Our ref: DOC19/867630-7

Your ref: SSD 9143

22 October 2019

Subject: Goulburn Poultry Processing Mixed use development – SSD 9143 – Comments on EIS and recommendations for biodiversity Conditions of Consent

Title: Figure 3 - Vegetation and Survey Effort Date: June 2019

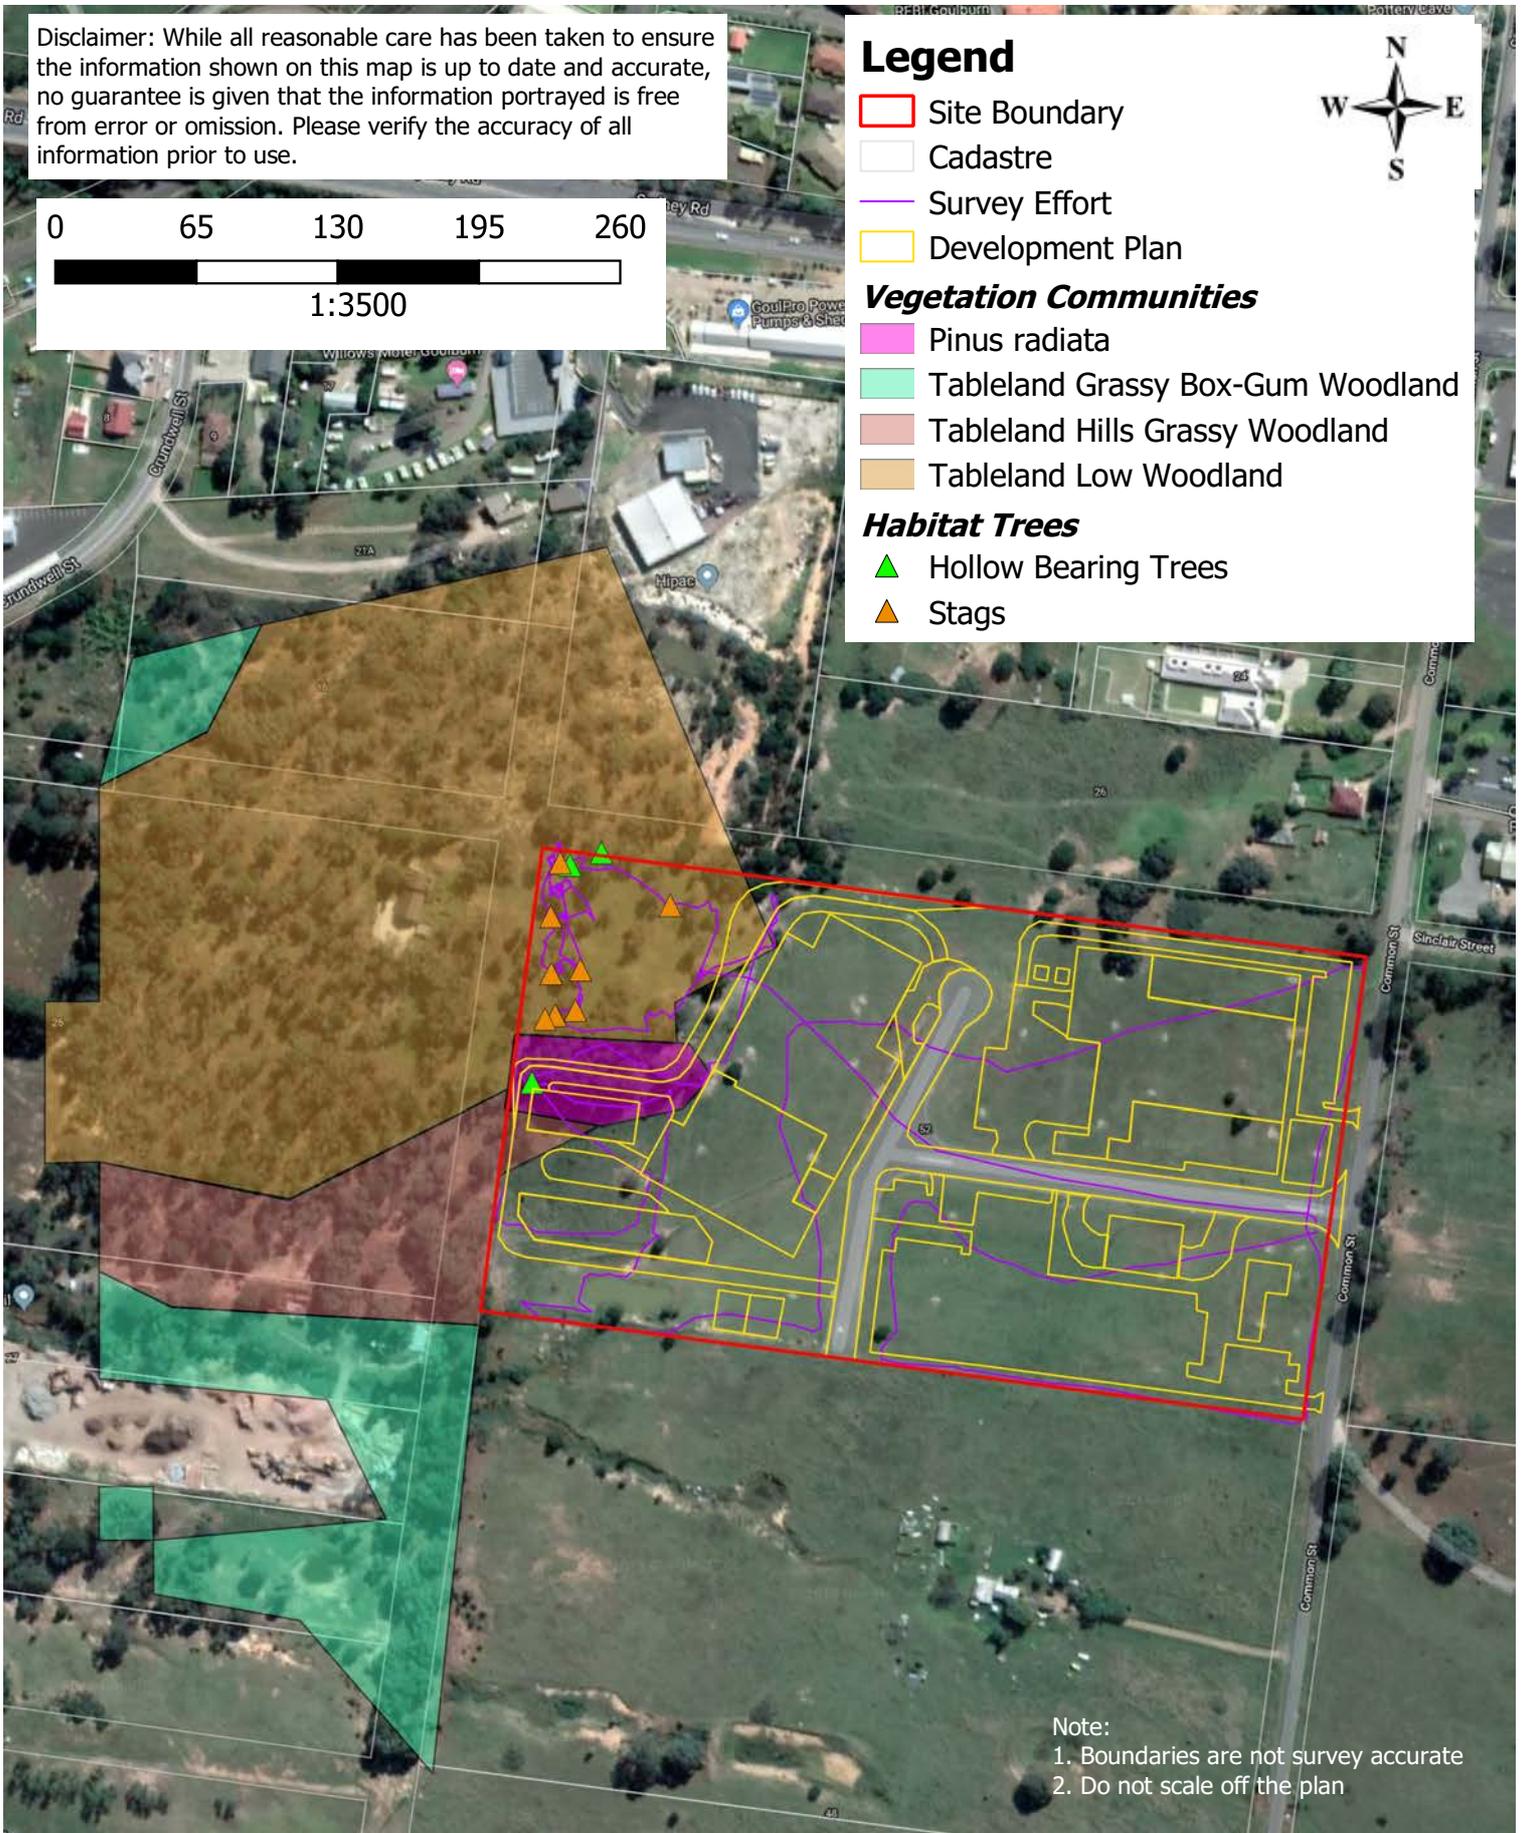
BCD is satisfied with the 5-Part test and justifications for the impacts to the biodiversity on site, however we do have concerns about the removal of any hollow bearing trees (HBT), the EIS's references that there are 3 HBT on the development area with at least 1 being proposed to be removed. We recommend these be avoided as they are essential habitat for many species. Please see attachment 1 for further comments and recommendations on the conditions of consent.

- Limit the removal to just one HBT, if avoidance is not possible. If required to be removed, the hollow should be salvaged and reinstalled within the retained area. A monitoring program should also be included within this program,

Figure A - Indicative archaeological test pit locations (blue squares) at Aboriginal sites GMUPA-3 and GMUPA-PAD1

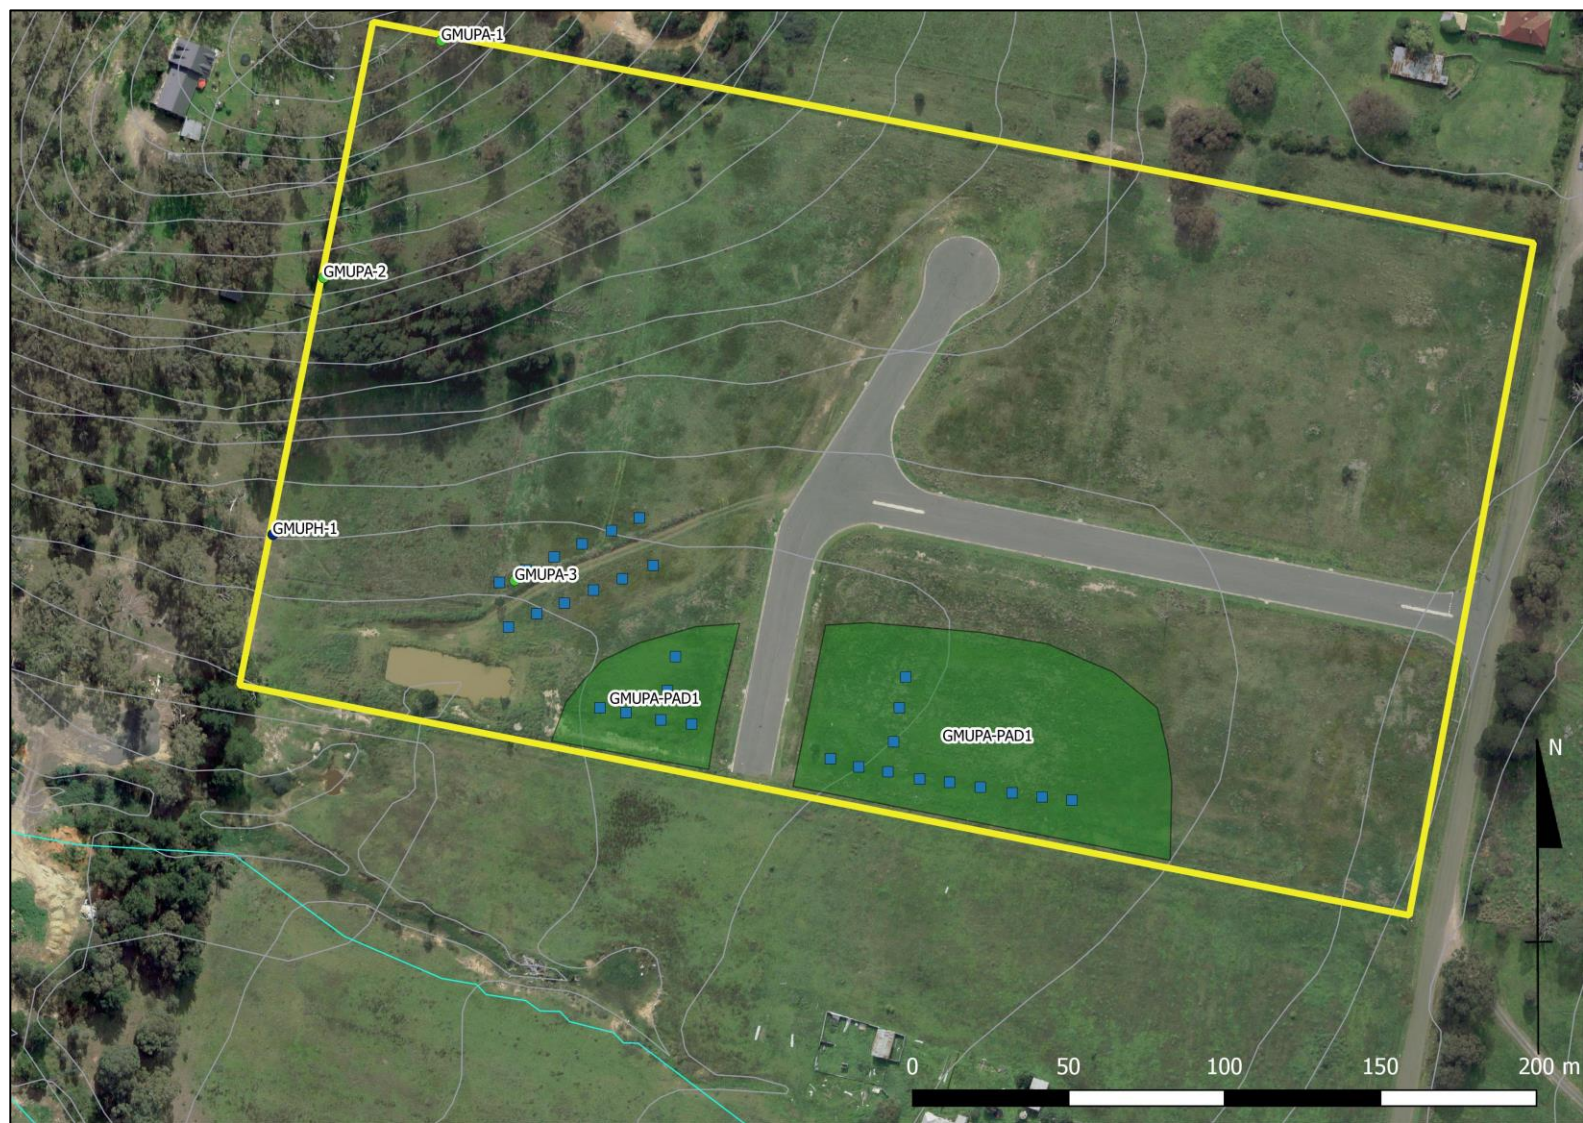
- GMUPA-3, GMUPA-PAD1 and GMUPH-1 are all within the impact area.
- We support the statement by NOHC that the scientific significance of Aboriginal sites GMUPA-3 and GMUPA-PAD1 can only be assessed through subsurface testing, but disagree with the suggested post-approval timing. Subsurface testing of sites GMUPA-3 and GMUPA-PAD1 is needed prior to approval because the significance of the sites is unknown and they will be extensively disturbed by the proposal:

- GMUPA-3 (Artefact Scatter and PAD) is situated in an area designated for truck parking and will be subject to considerable subsurface impacts in the form of excavation, levelling, compaction, and capping with asphalt.

- GMUPA-PAD1 (Potential Archaeological Deposit) is situated in an area designated for factory staff parking as well as a wastewater treatment plant and associated infrastructure. Subsurface impacts in this location would include excavation, levelling, compaction, installation of building footings, and capping with asphalt.
